Drafted 10 October 2011

**Planning Application, Ribble Valley District
3/11/0660 26 Calderstones Green, Pendle Drive, Whalley**

Title
PLOT 26 HOUSE (TYPE D1651)
AS CURRENTLY BEING BUILT
PLUS PROPOSED ALTERATIONS.
"PROPOSED"

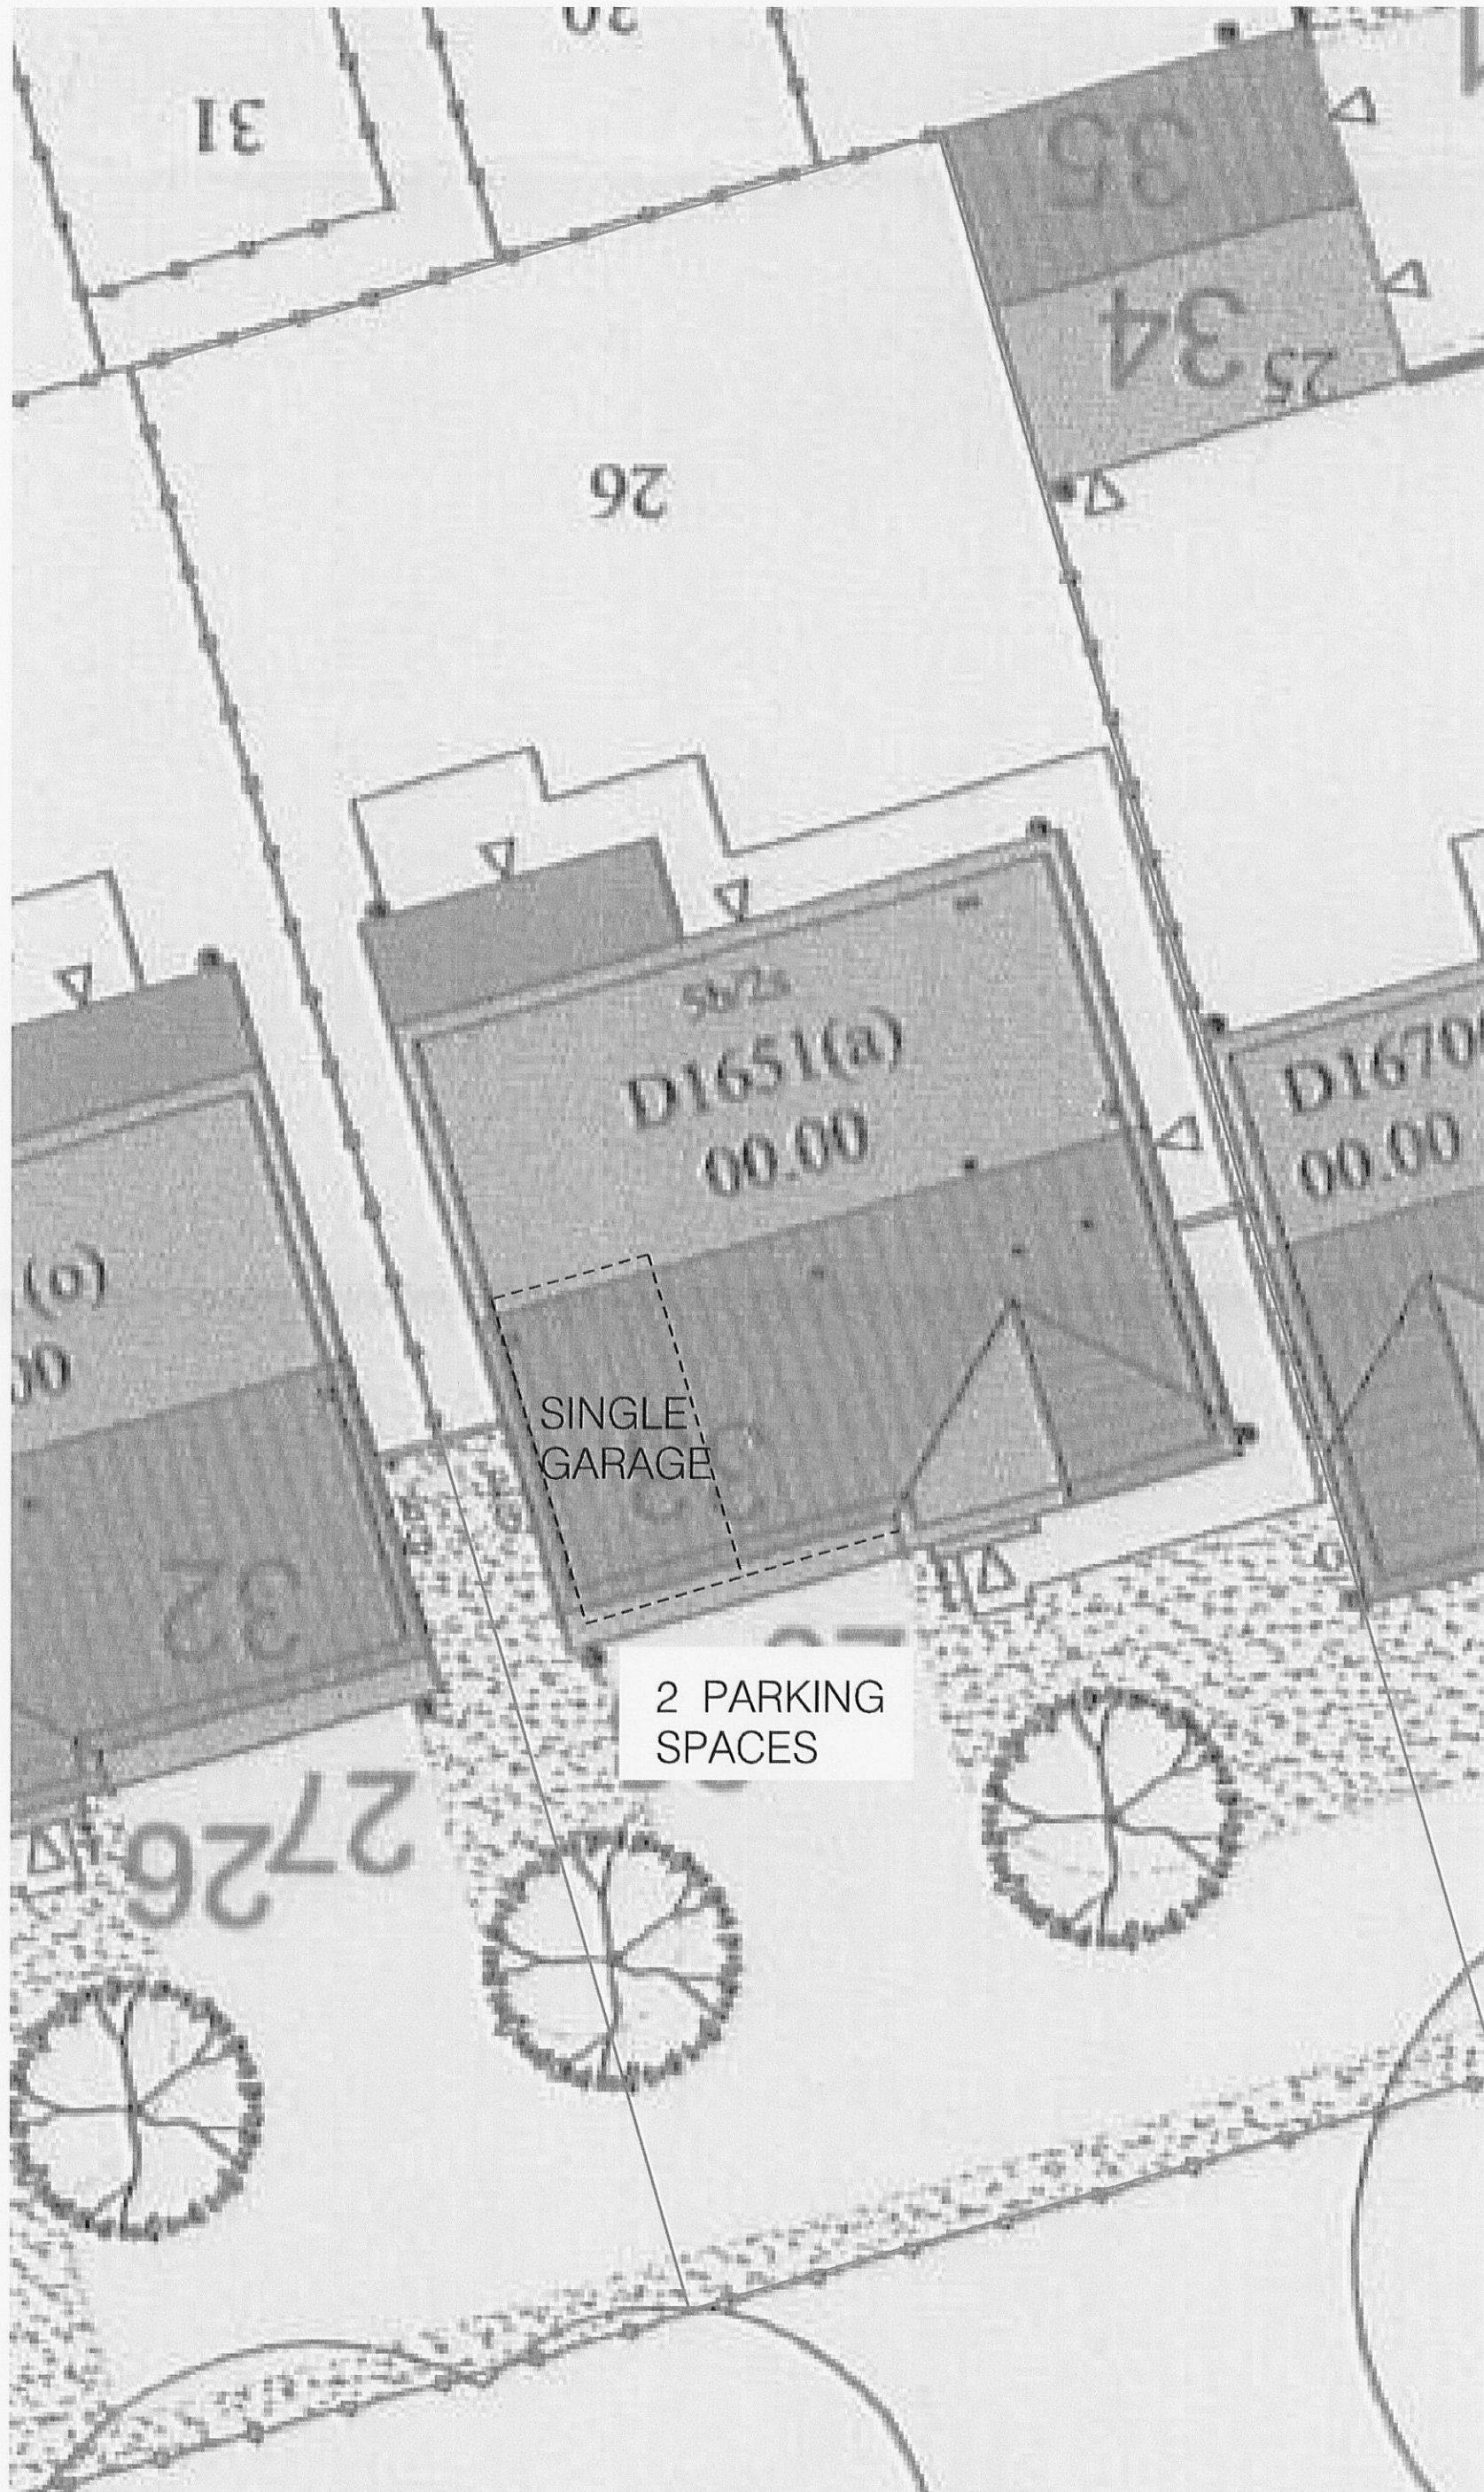
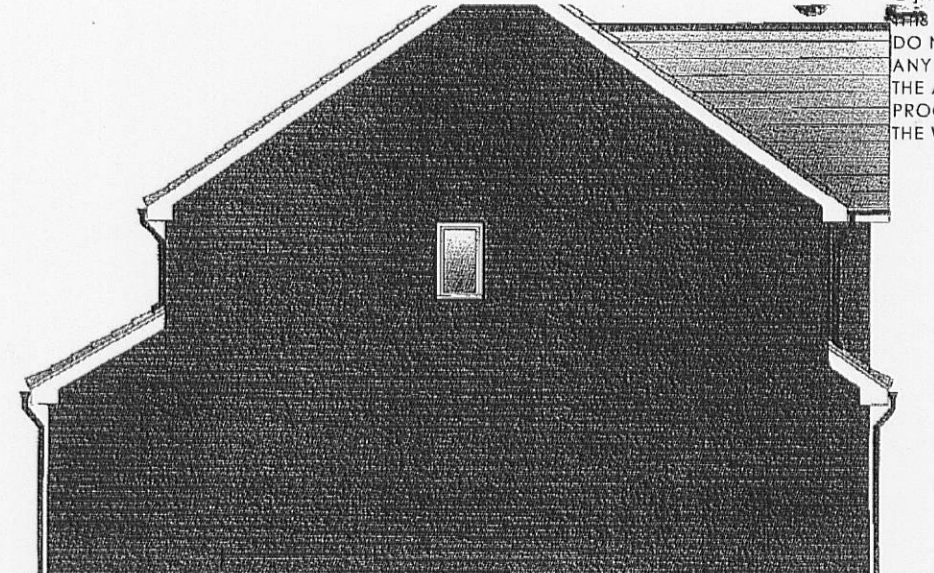
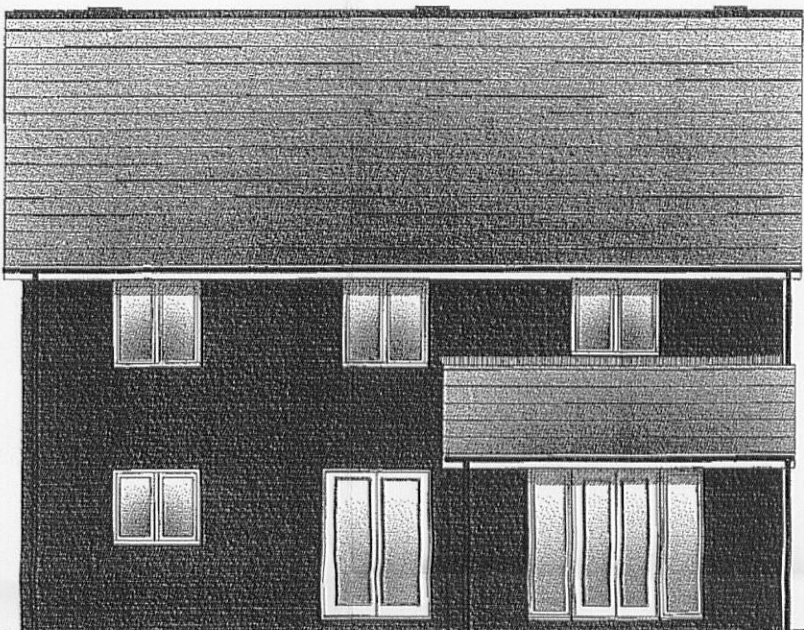
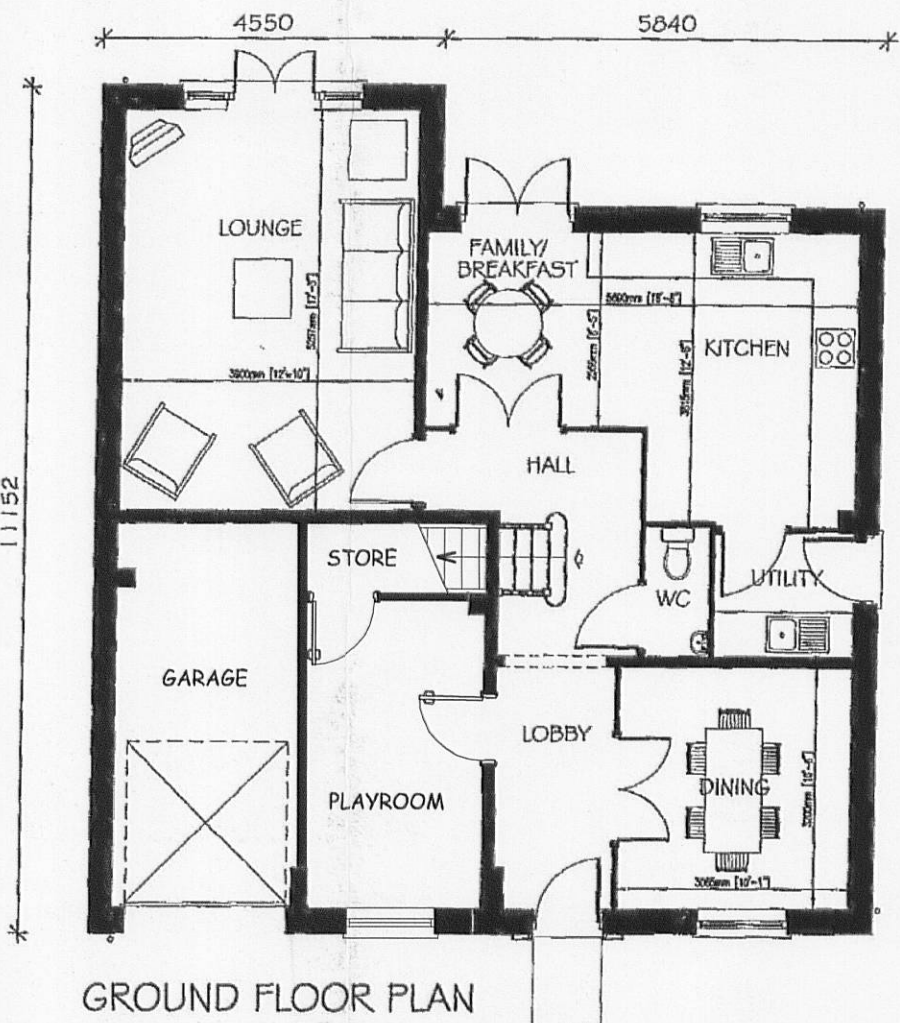
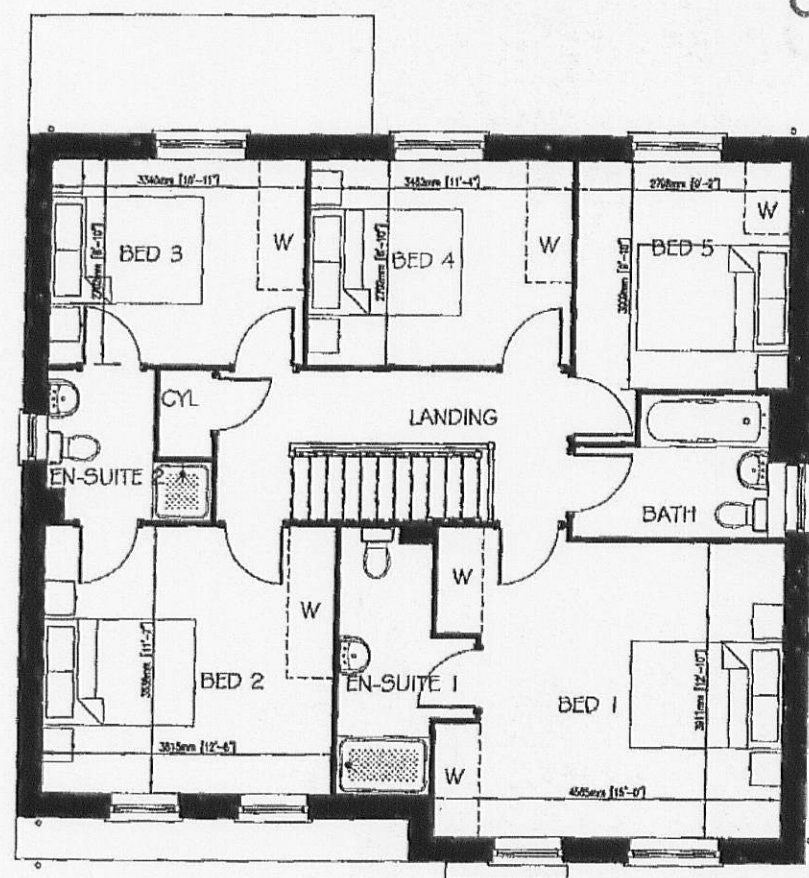
The residential layout provides for three off road parking spaces to the redeveloped property.

One of the spaces shown is from an integral garage. In order to secure the necessary parking to this property in perpetuity, it is necessary to include a condition retaining the use of this space for garaging

1. In order to retain the use of this space for the garaging of a private vehicle, the future development of this area for residential space or for exclusively storage purposes is to be prohibited
